SICEEP PPP - Response to Public Submissions

PROPOSED JUNE 22 3PM

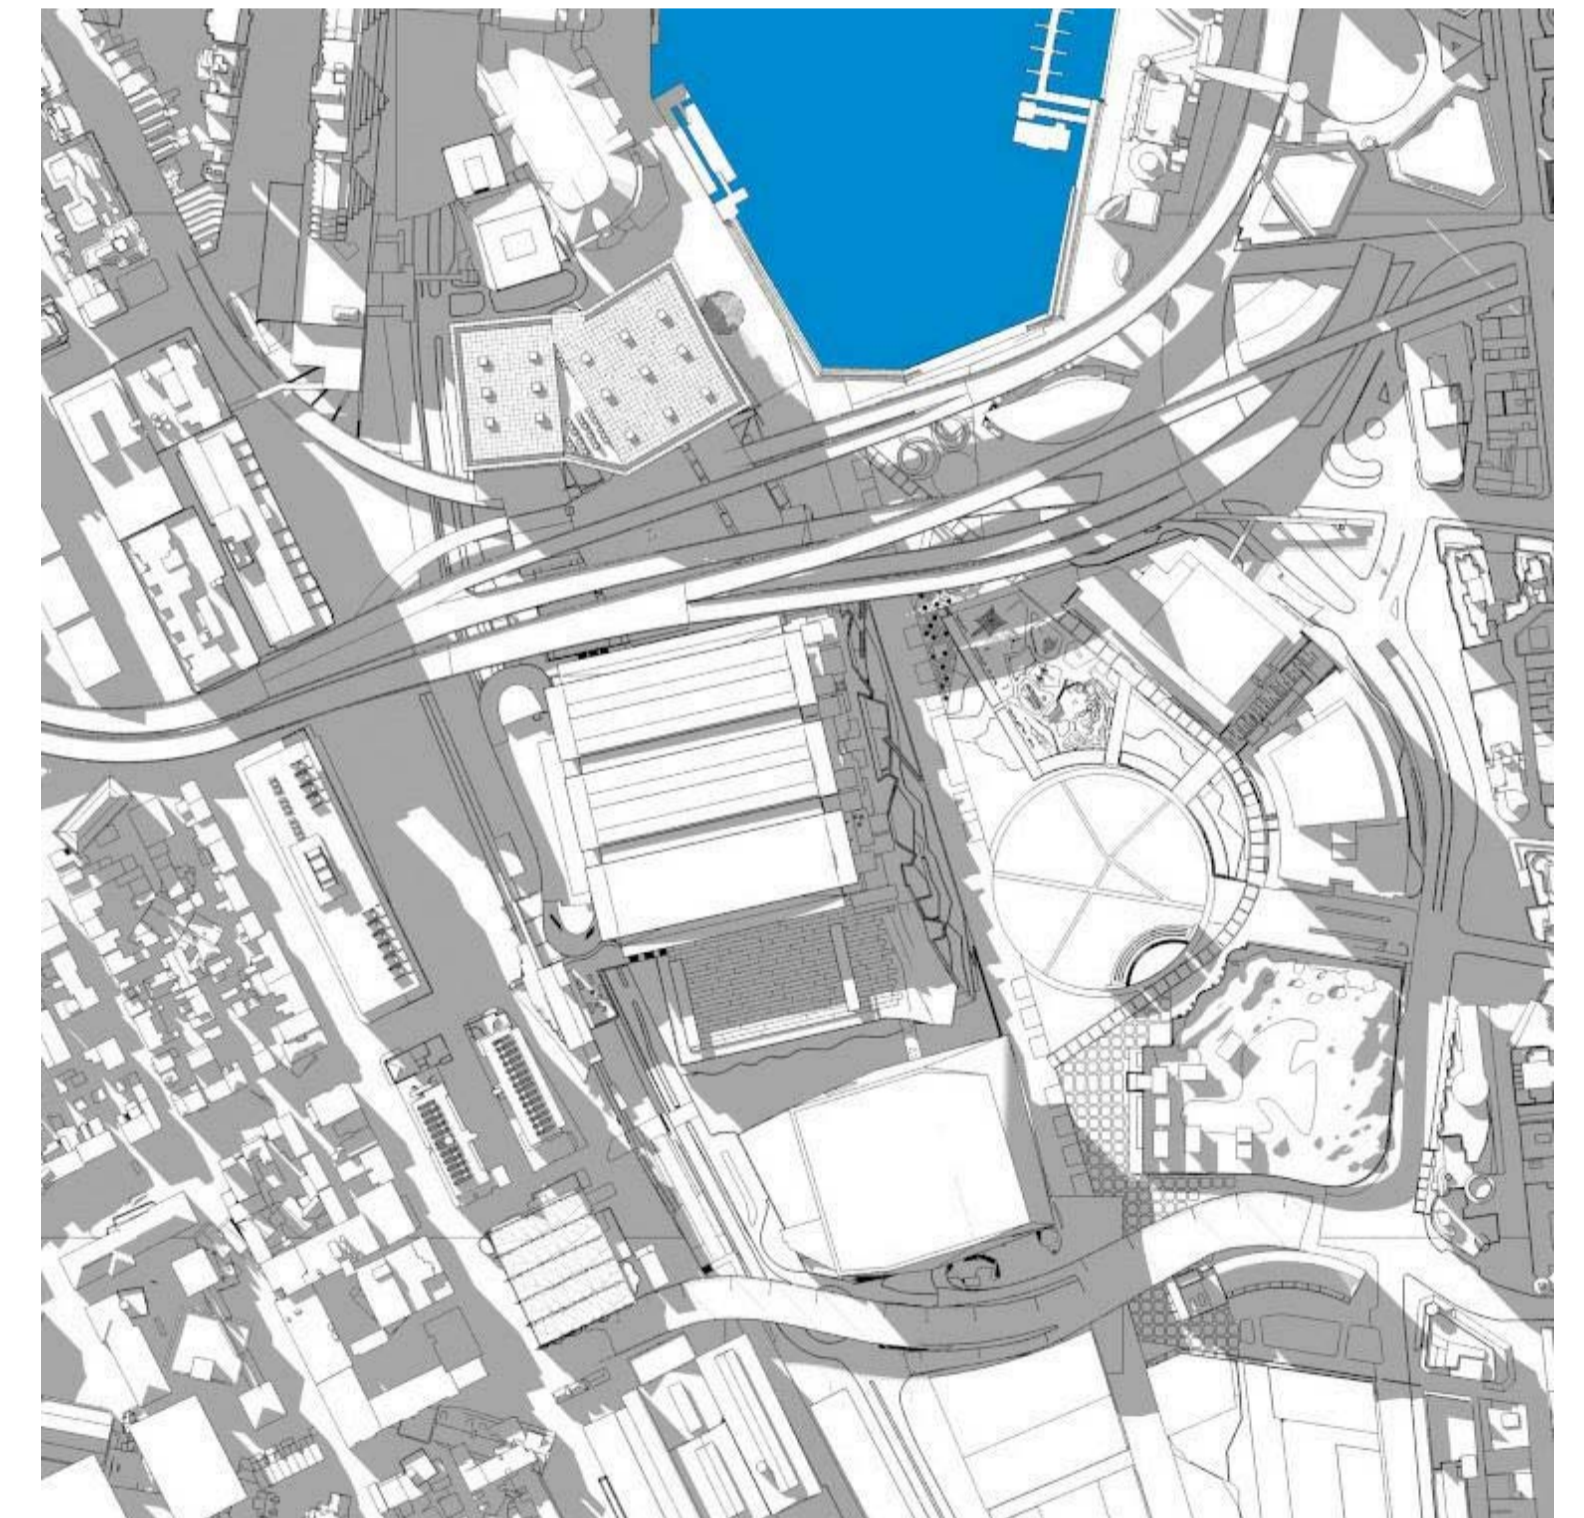
8	Unacceptable level of overshadowing on public open space	At the winter solstice on 21 June (i.e. the worst-case scenario for overshadowing), the buildings proposed under SSDA1 will not overshadow Tumbalong Park between 9am and 3pm, and there would be only minimal overshadowing of the Chinese Garden of Friendship forecourt (there would be no overshadowing of the garden itself). At 3pm on 21 June there would only be partial overshadowing of the north-south boulevard during the worst-case scenario of 3pm. In light of the above, it is considered that the proposed PPP Site redevelopment will not result in any adverse impacts upon amenity within the adjoining public domain as a result of the proposed development.
4	Reduced amenity of public open space through removal of water features	As part of the Darling Harbour Live vision the Public Realm is a series of interactive water features for children of a variety of ages which combine to create a connected urban stream from south to north, along the Boulevard and terminating at the Harbour's edge. The removal of the existing water features will improve pedestrian permeability and provide a more interactive experience for visitors to the precinct. The Woodward Fountain, which is going to be listed on the State Heritage Register, will be retained as part of the proposed development, with the revised scheme seeking to increase the curtilage between the ICC and the water feature.
